Tuesday, 29 August 2023

**Subject: Response to Submission Report for the Narwee Parklands Care Community State Significant Development Application (SSD-45024776)
59-67 Karne Street North, Narwee**

1 : 10

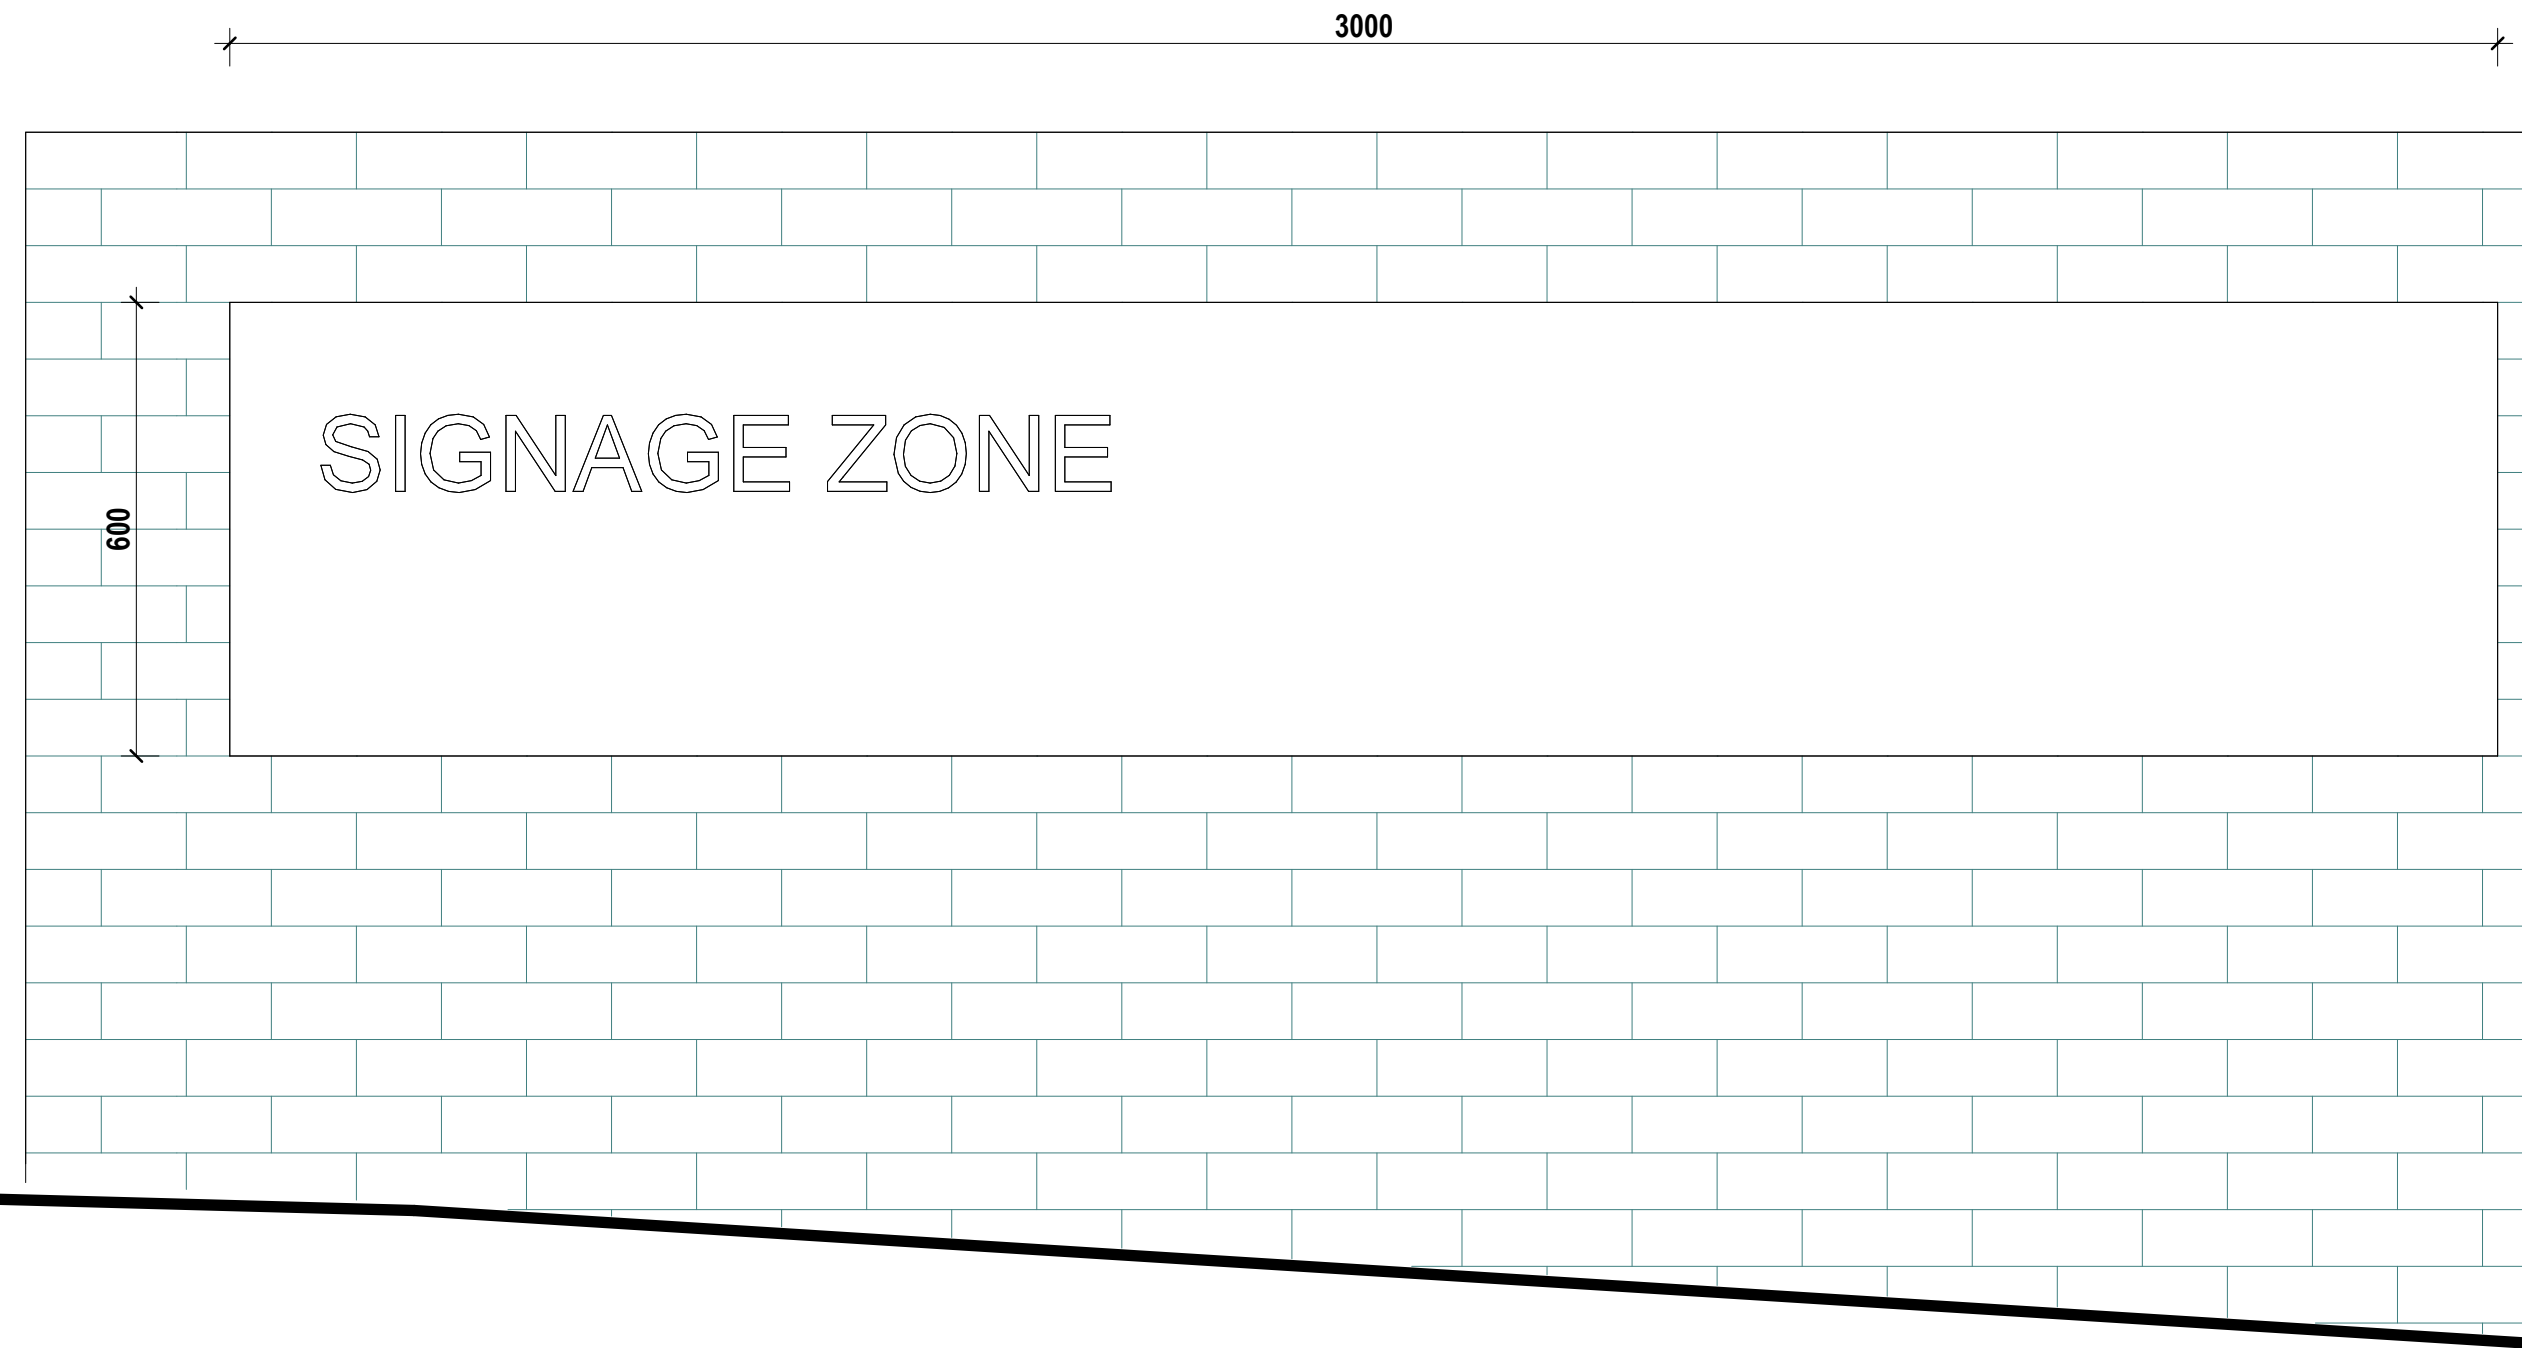
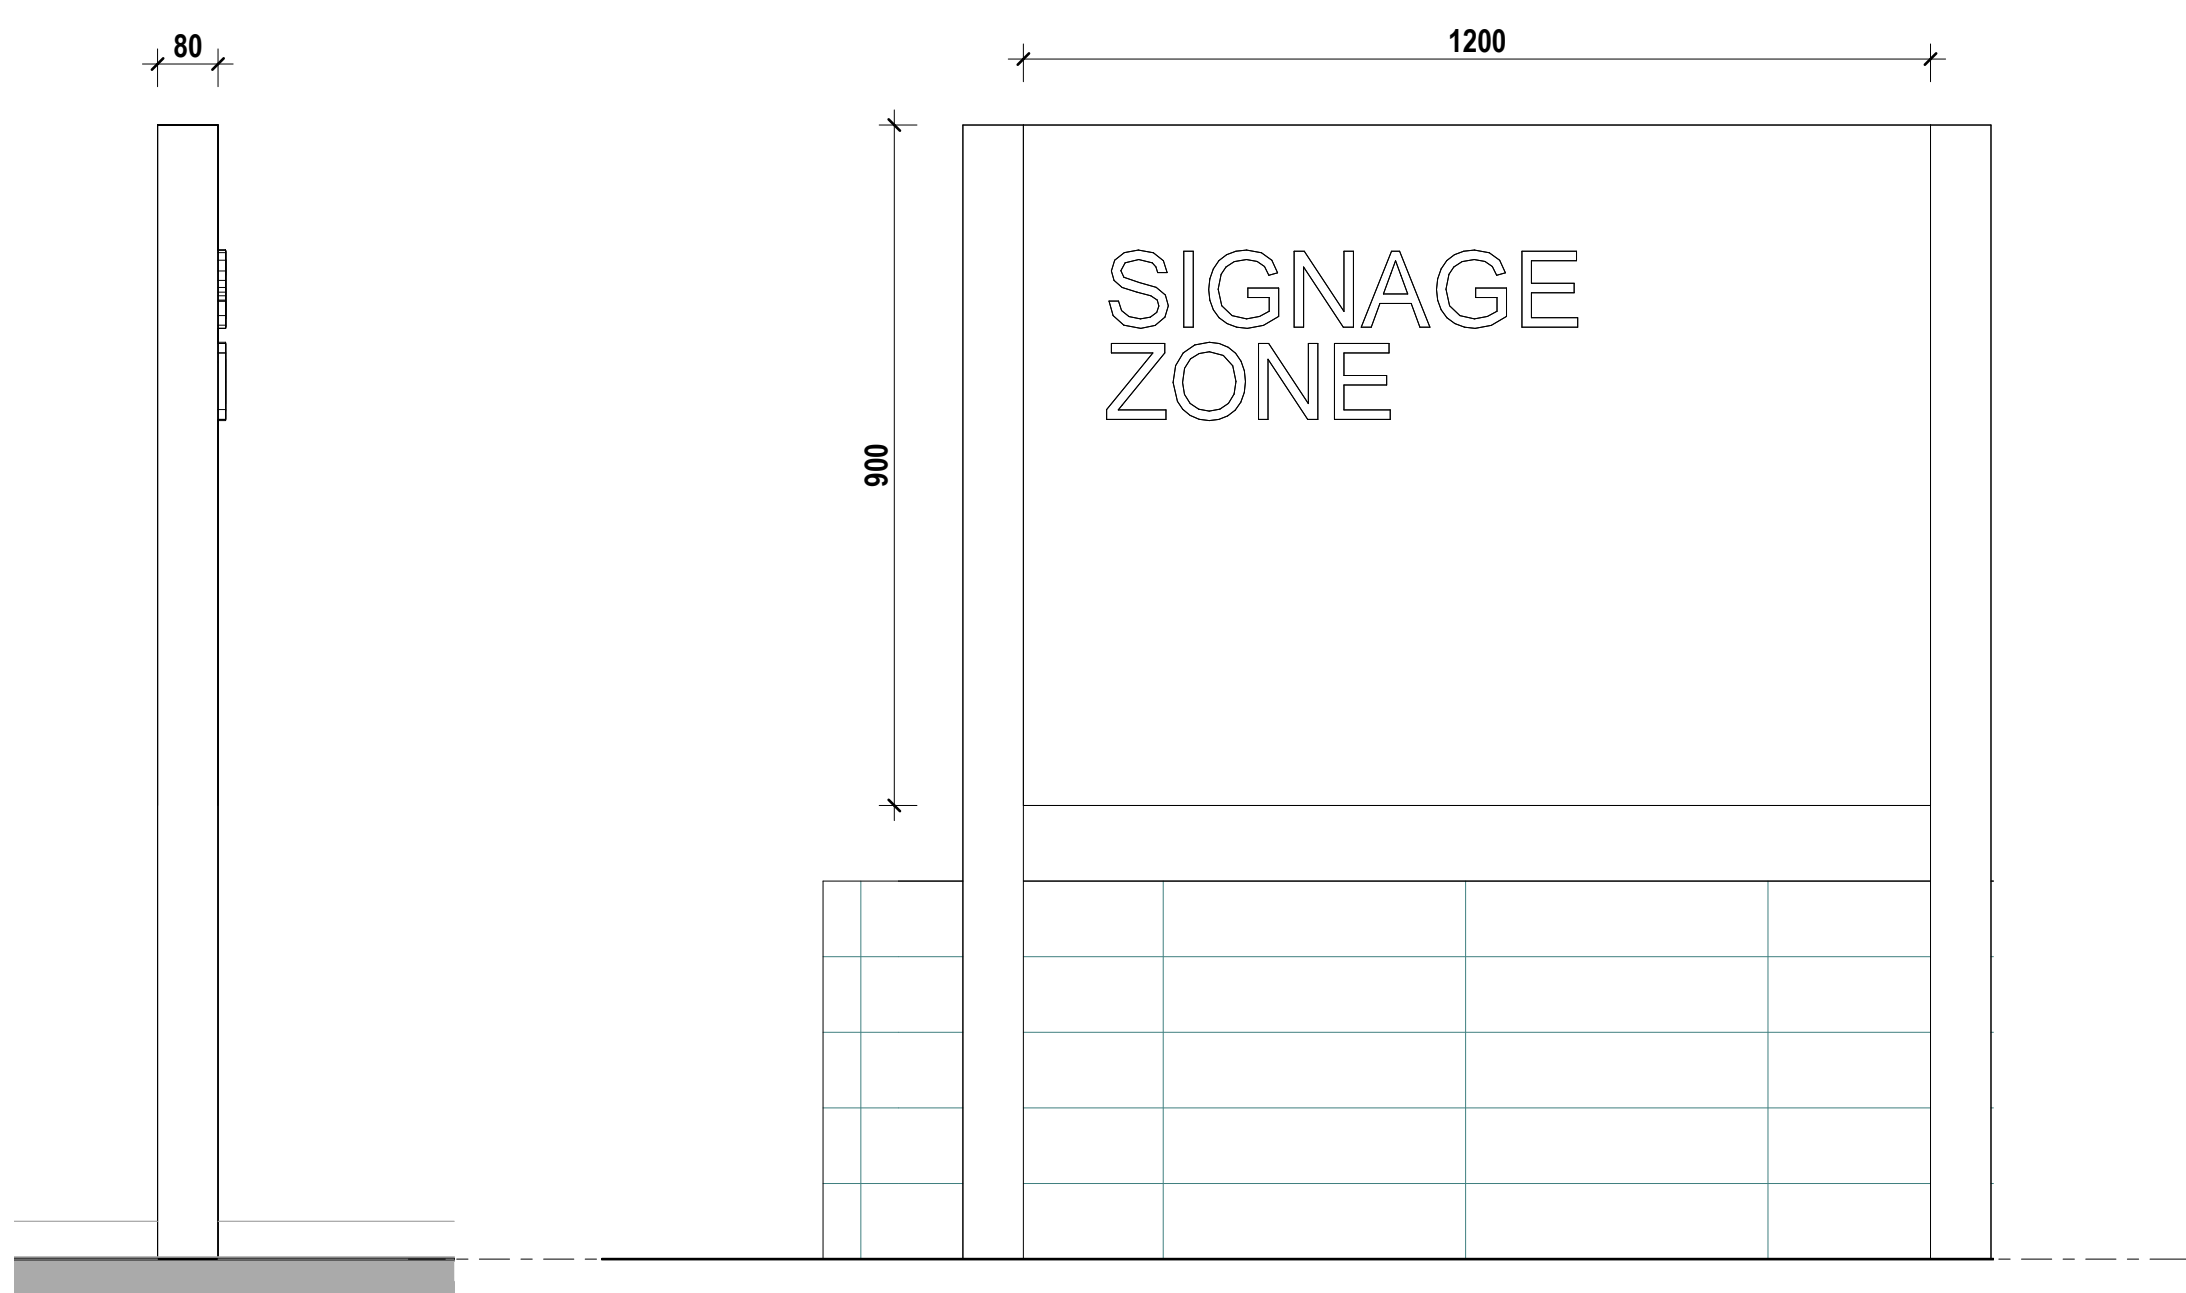
GSA / EU	(a) Clarification is sought on the location of business identification and wayfinding signage as there are inconsistencies between the Environmental Impact Statement (EIS), elevations and floor plans. Particularly, the EIS states 4x business identification signs are to be located on the western elevation. However, the architectural plans demonstrate signs 01 and 04 on the northern elevation and 2x sign 02's on the western elevation. Furthermore, sign 04 is not indicated on the northern elevation plan and the western elevation plan demonstrates 3x signs, while the floor plans only show 2x signs.	Northern Elevation - Signage S1 & S4. Both non-illuminated. Western Elevation - Signage S2 x 2nos & S3-A (illuminated) + S3-B (illuminated)	Refer to DA2001[F] DA6200[C] DA6201[A]
GSA	(c) Elevations of fencing across the entirety of the site are to be provided.	Fencing elevation provided.	Refer to DA3010[A]
